Your Ref: OWQC21781
Our Ref: EP/16/19/HH
Please ask for:
Mr Z Denton

19th March 2019

Single storey rear extension with an addition of a second floor including a rear dormer and gable end window
2 Hillview Crescent East Preston

DRAWING TITLE
Proposed Elevations

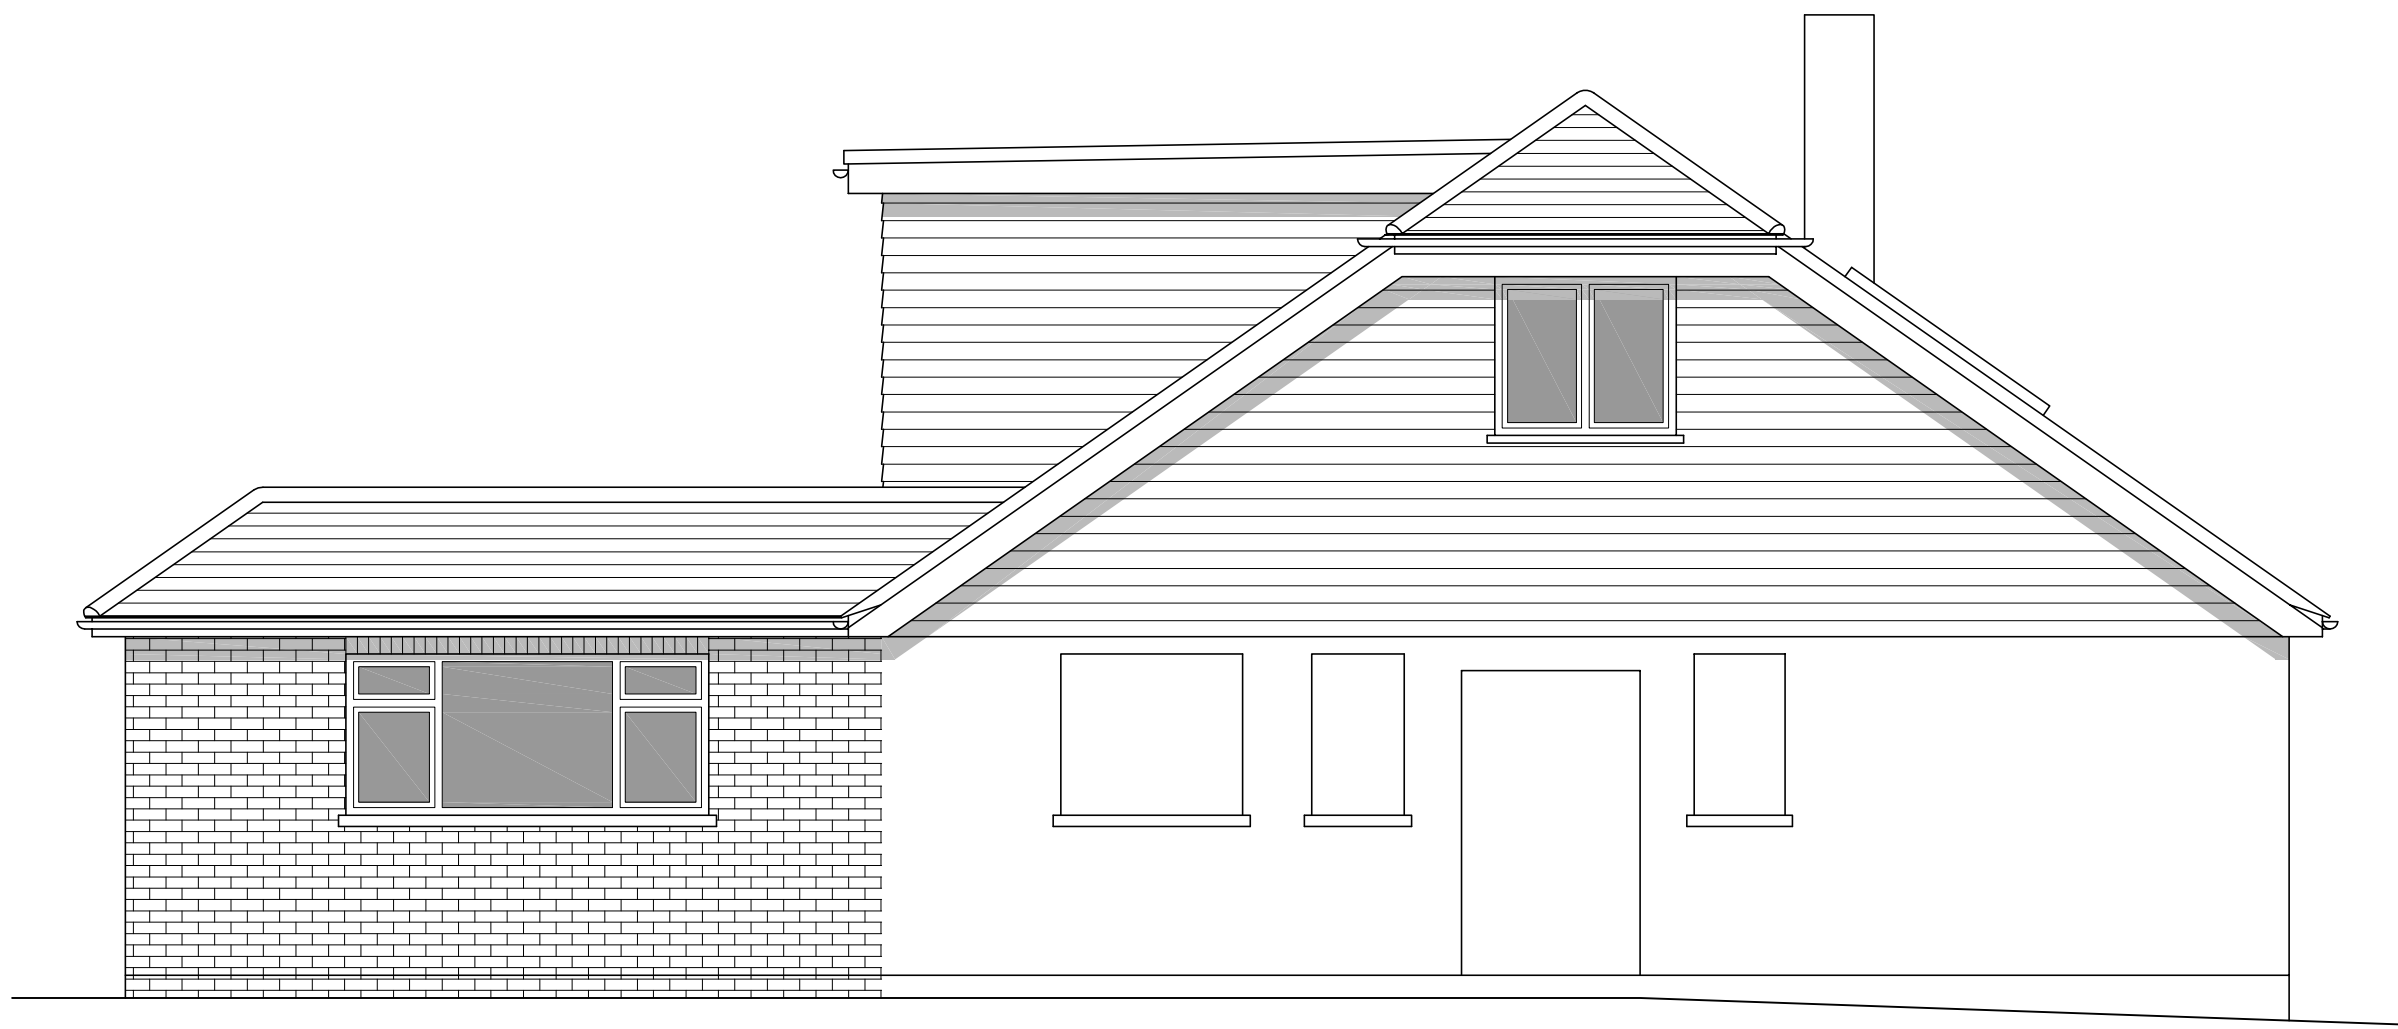
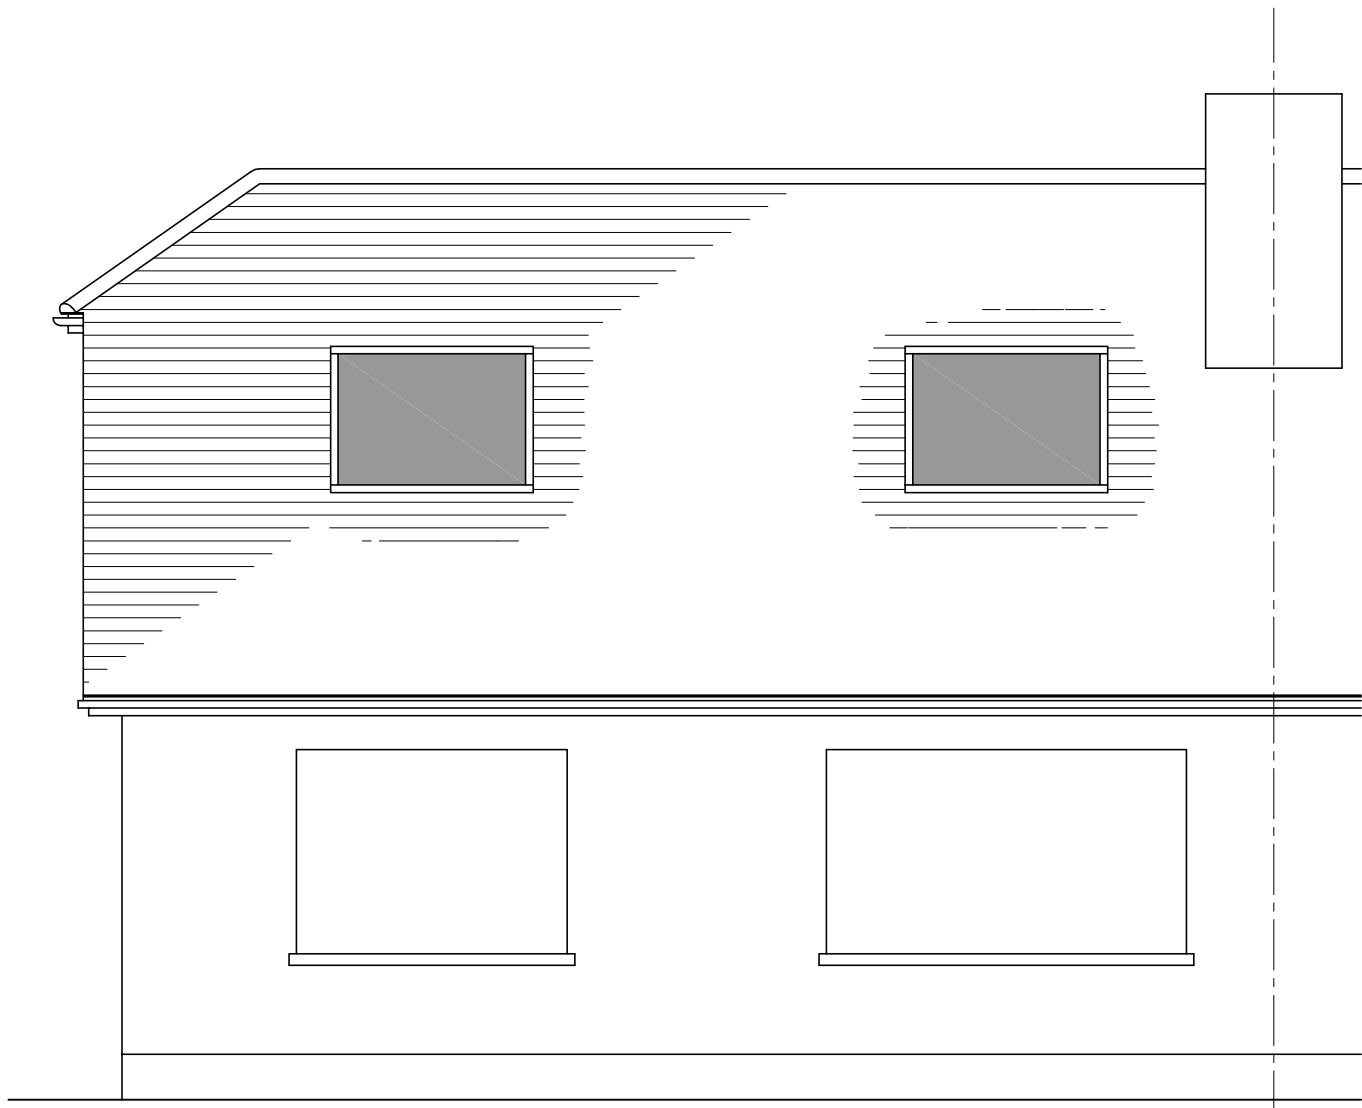
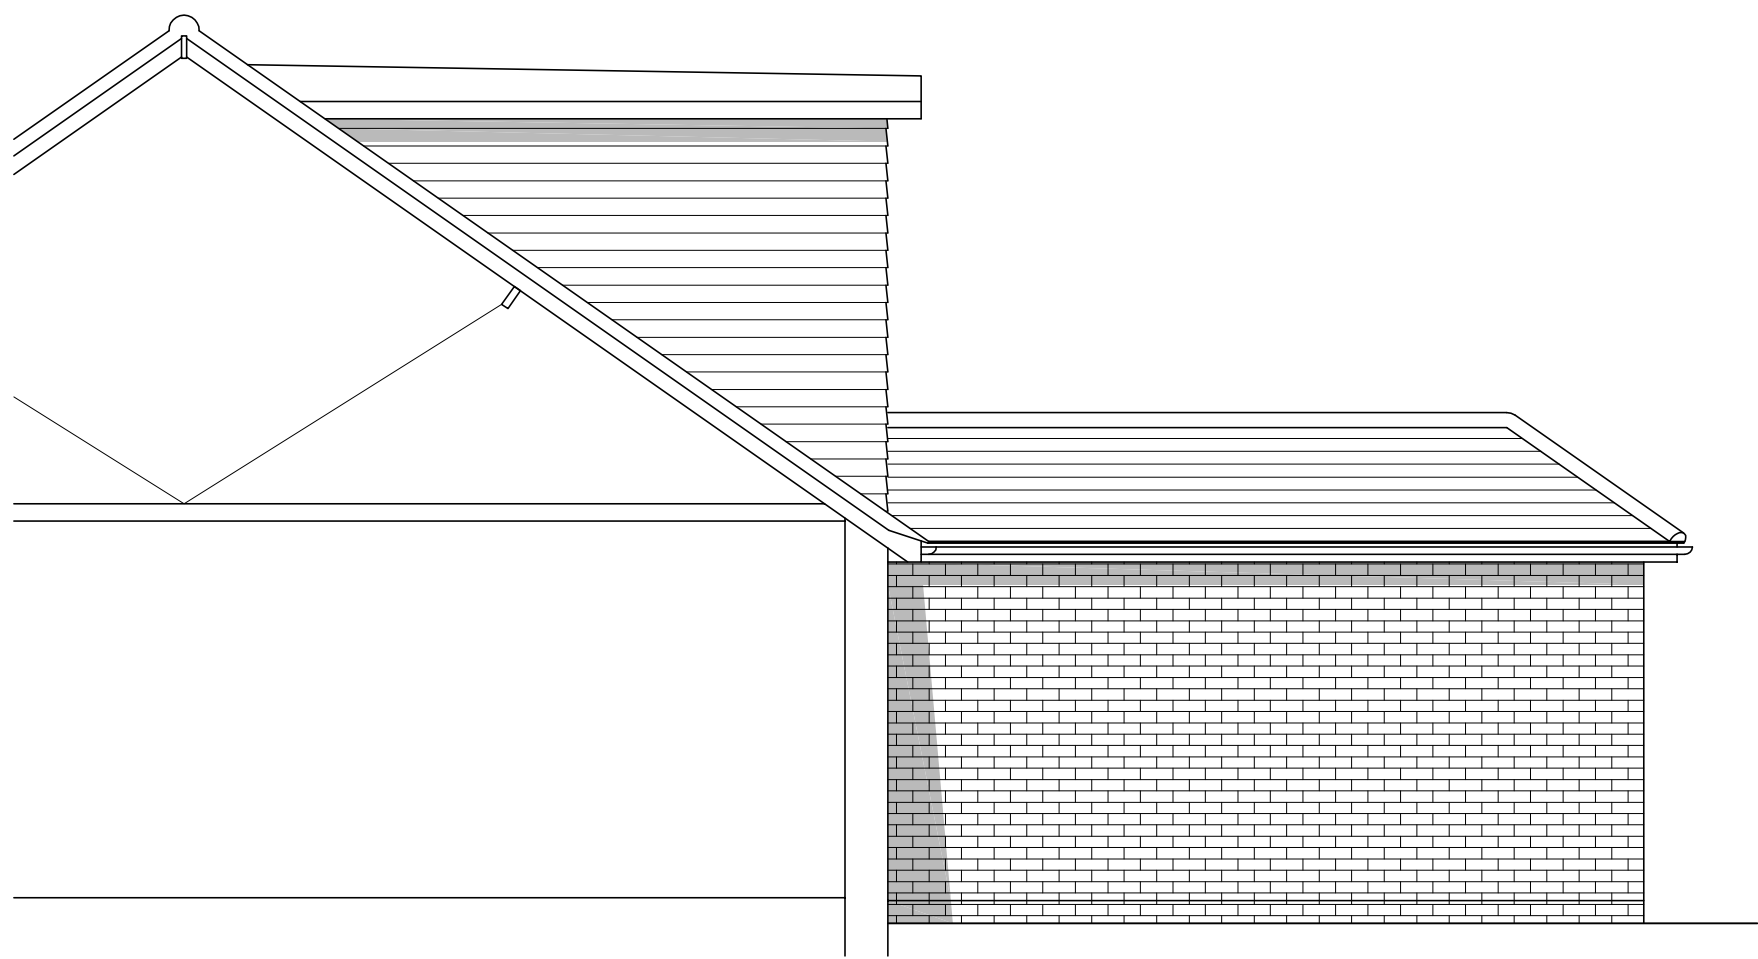
The committee felt the proposal still did not fit in with the existing streetscene. The committee did not consider the proposed dormer was Permitted Development as it was not stepped up from the eaves. It was also not subservient to the roof as a whole. The committee believed the hip to gable conversion will result in an unbalanced property in a prominent corner location.
